DELEGATED DECISION TO DETERMINE PLANNING APPLICATIONS

Reference No: 2020/62/92626/E
Site Address: 235, Leeds Old Road, White Lee, Batley, WF17 9AQ
Description: Erection of single storey rear extension
Recommending Officer: Jennifer Booth

DECISION - WITHDRAWN

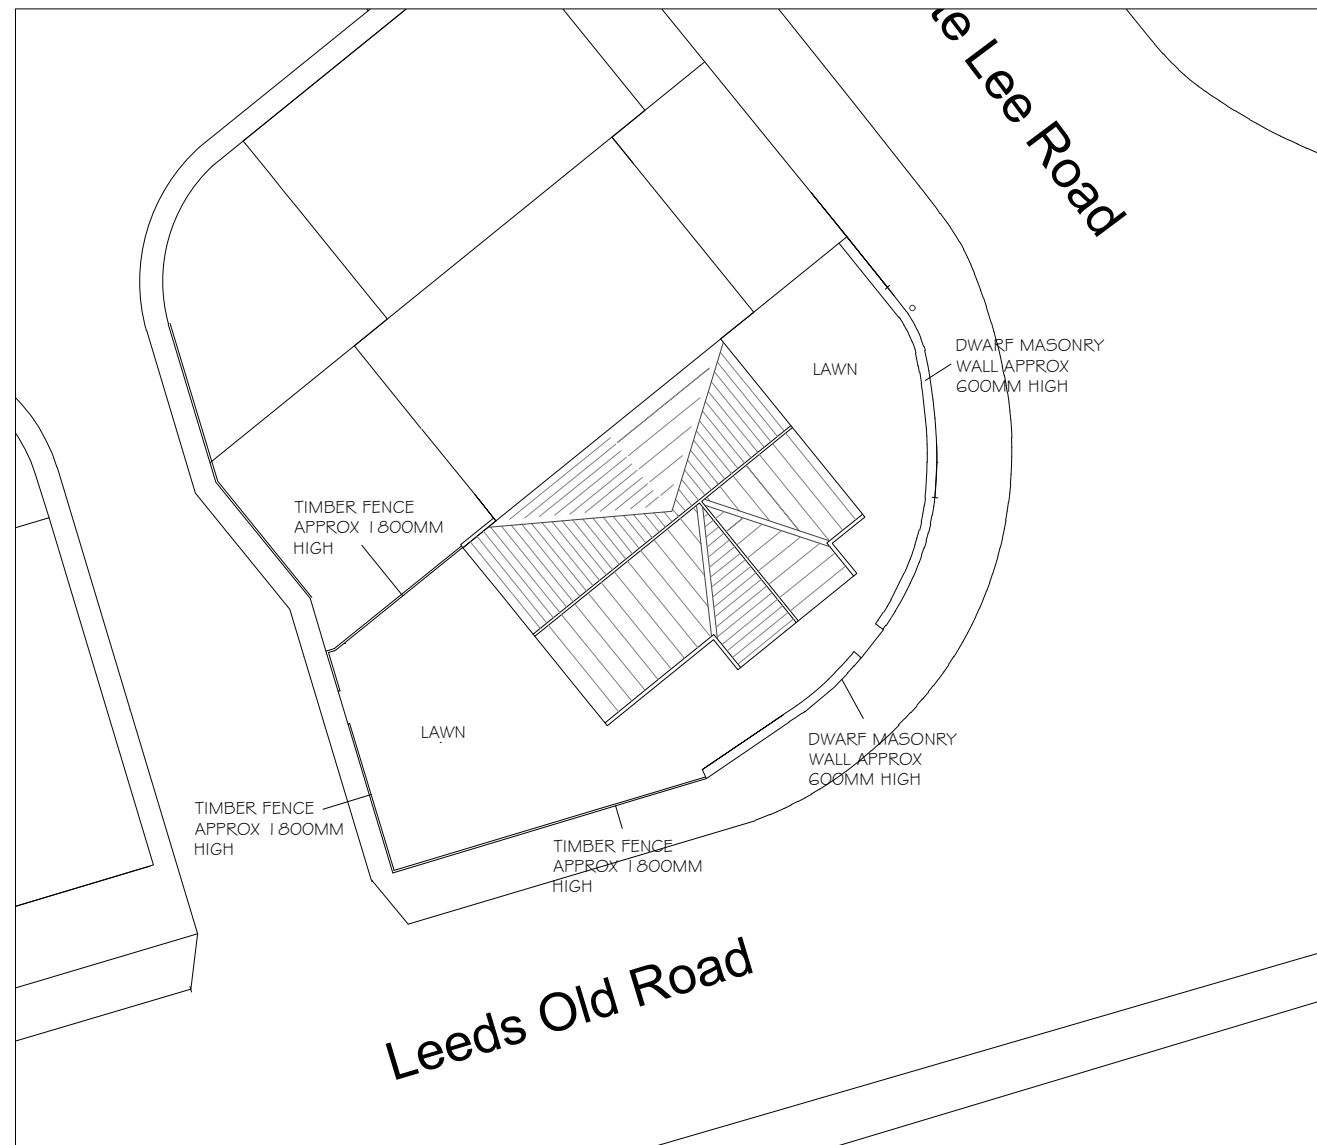
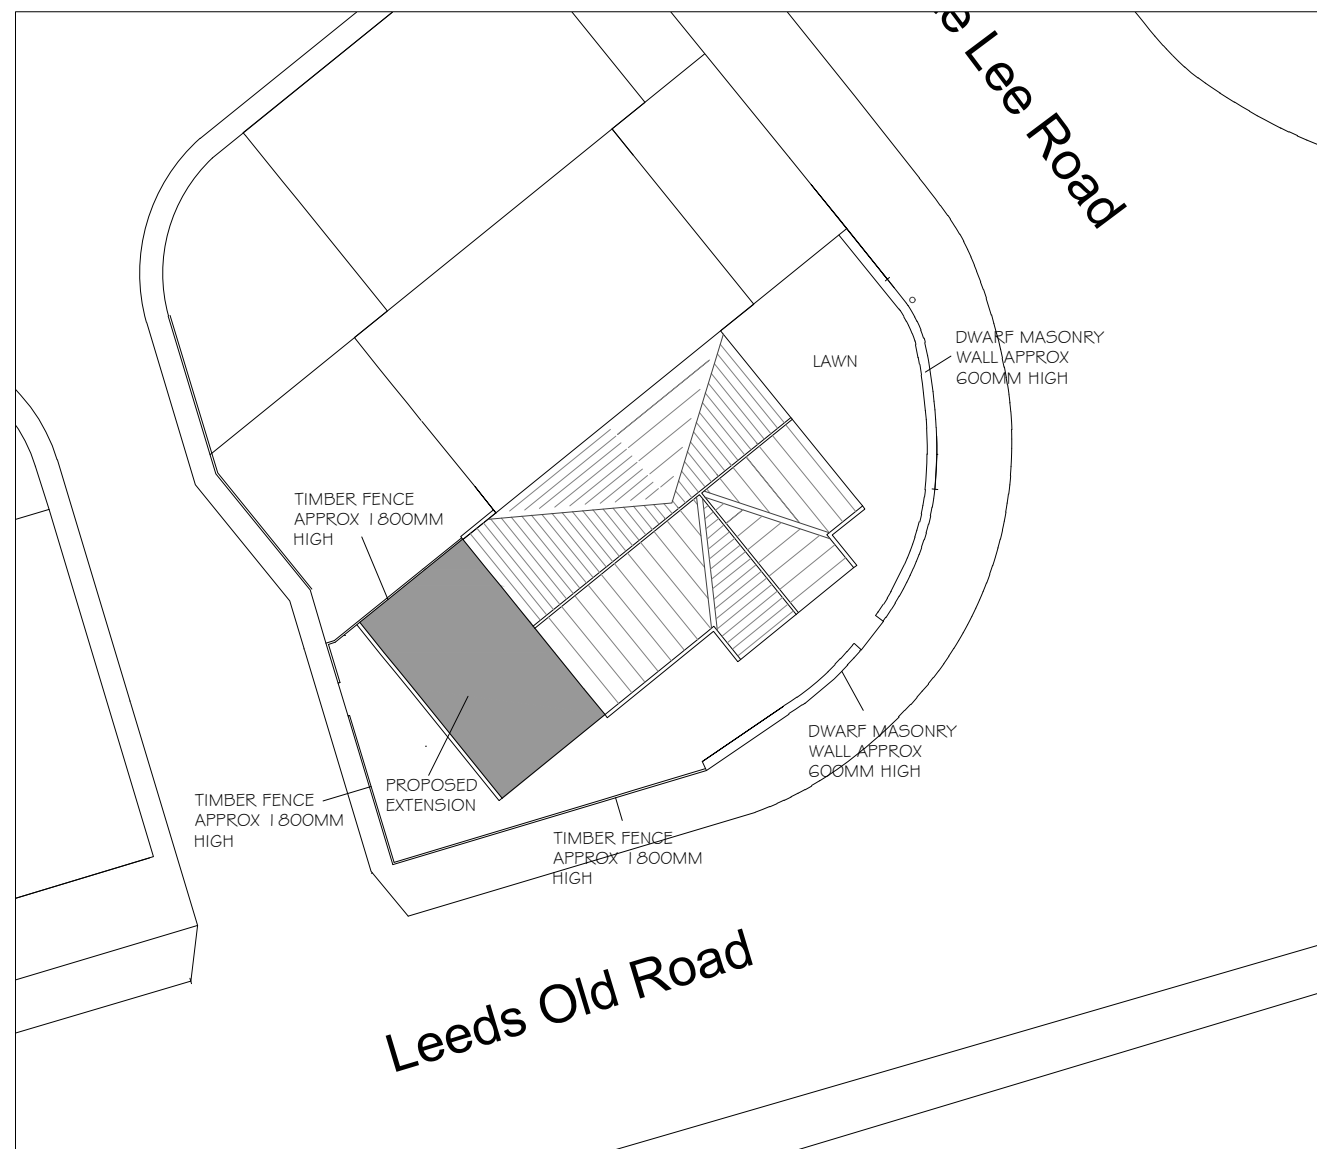
It has also been noted that both the current application and the previously approved scheme appear to include a change to the fencing. The approved scheme allowed a single storey rear extension only.

I would draw your clients attention to a condition of the original planning permission for the development as a whole under 2016/91977, specifically condition 4, which prevents any kind of development which would restrict visibility. If the fencing were to be moved as indicated on the proposed plans, this would restrict visibility and would be in breach of the condition.

4. Sightlines of 2.4m x 43 metres shall be cleared of all obstructions to visibility exceeding 1 m in height before the superstructure of any dwelling is commenced and these shall thereafter be retained free of any such obstruction.

Ground Floor Plan
As Proposed

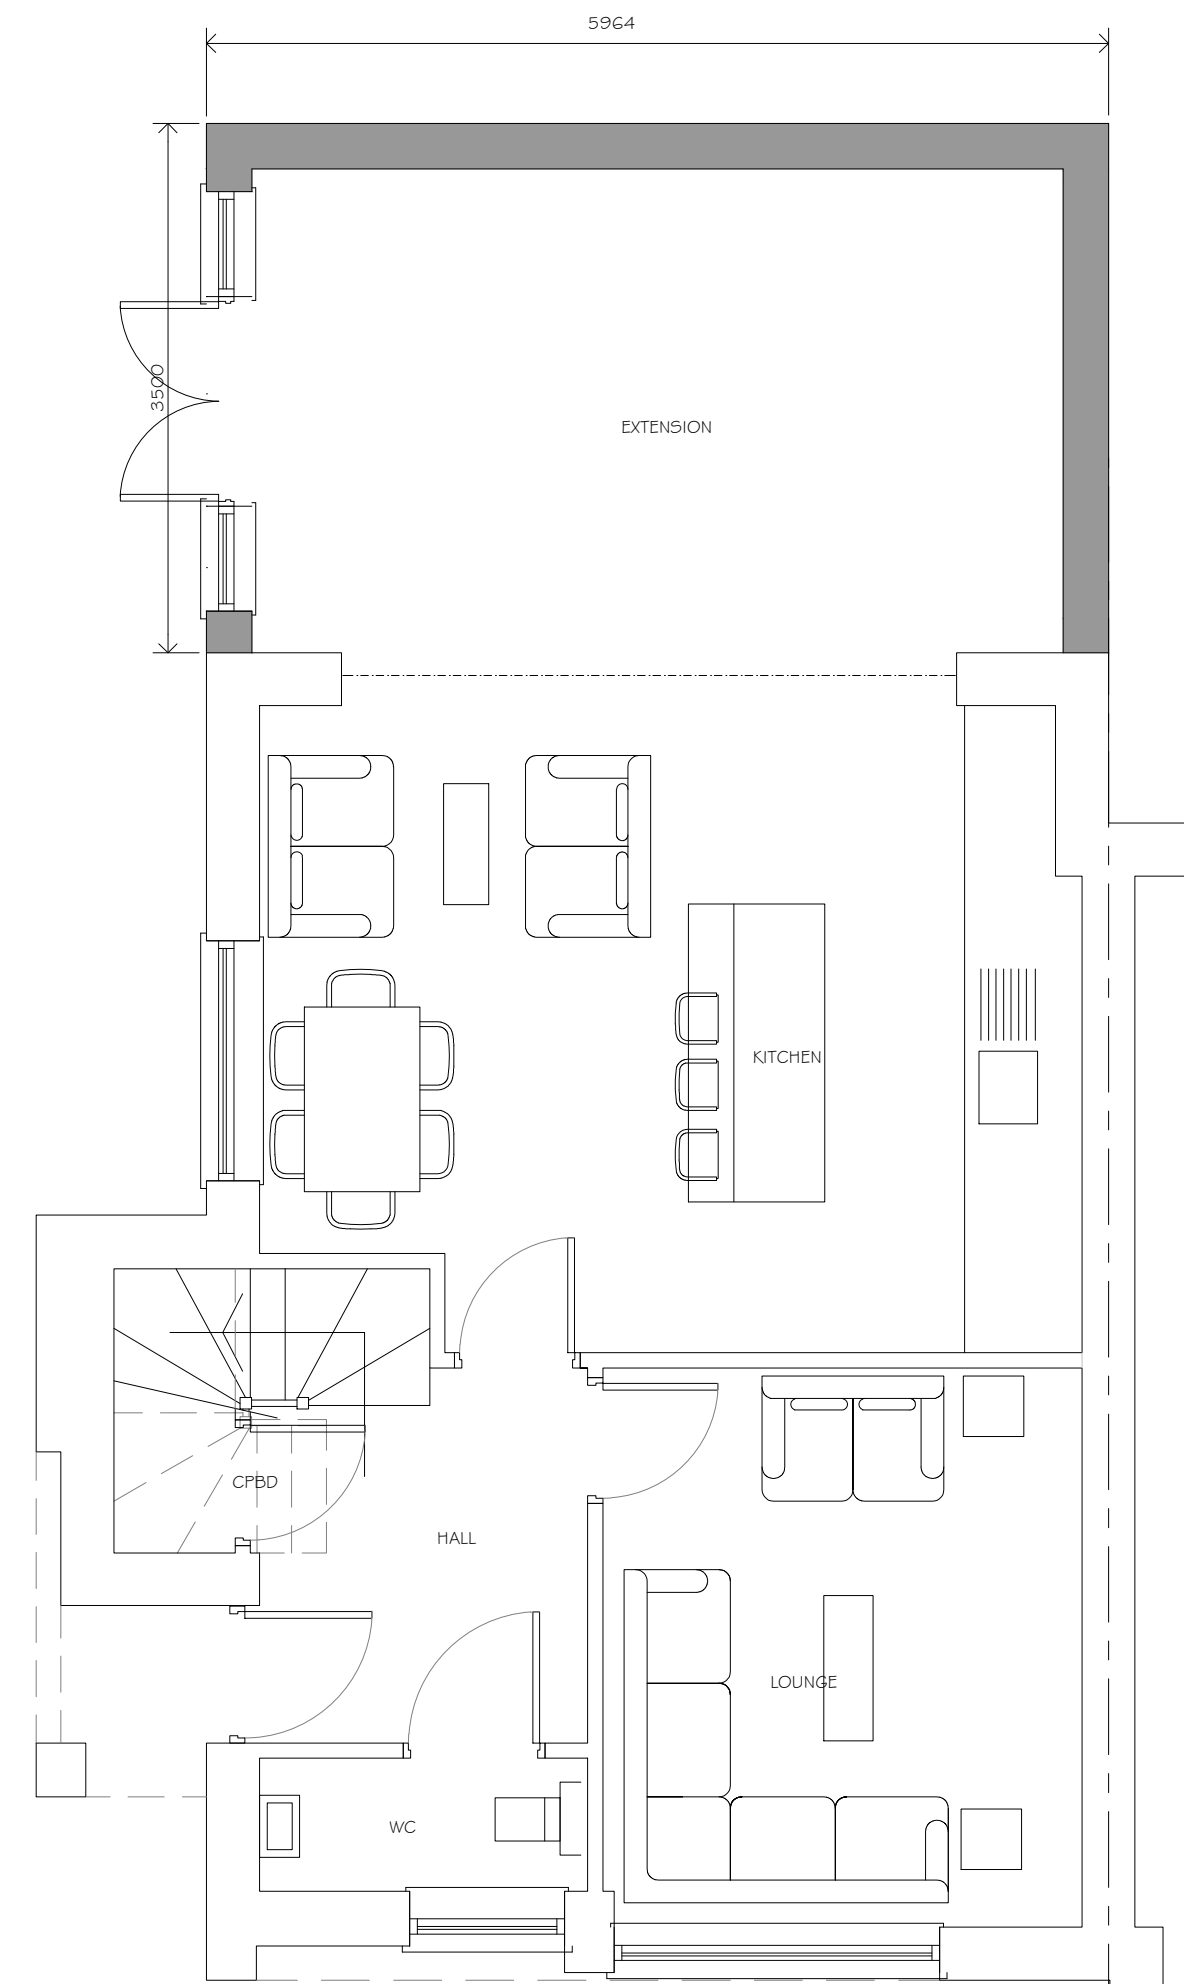
Your applicant has left me a voicemail asking for an update. This application is still in its consultation period which will not expire till 01/10/2020. However, I have discussed the current application with the team leader and we would not be inclined to support any further extension to the property. The property has a very limited amenity space and is in a prominent position within the new development. Allowing any further extension would result in the formation of an incongruous feature out of

character with the modest development and failing to comply with LP24 in terms of visual amenity. Furthermore, the position of the dwelling further back than the adjoining property is such that enlarging the extension would have a harmful effect on the amenities of the occupiers of the adjoining property in terms of overshadowing in the middle of the day and the formation of an overbearing and oppressive impact which would fail to comply with LP24 in terms of residential amenity.
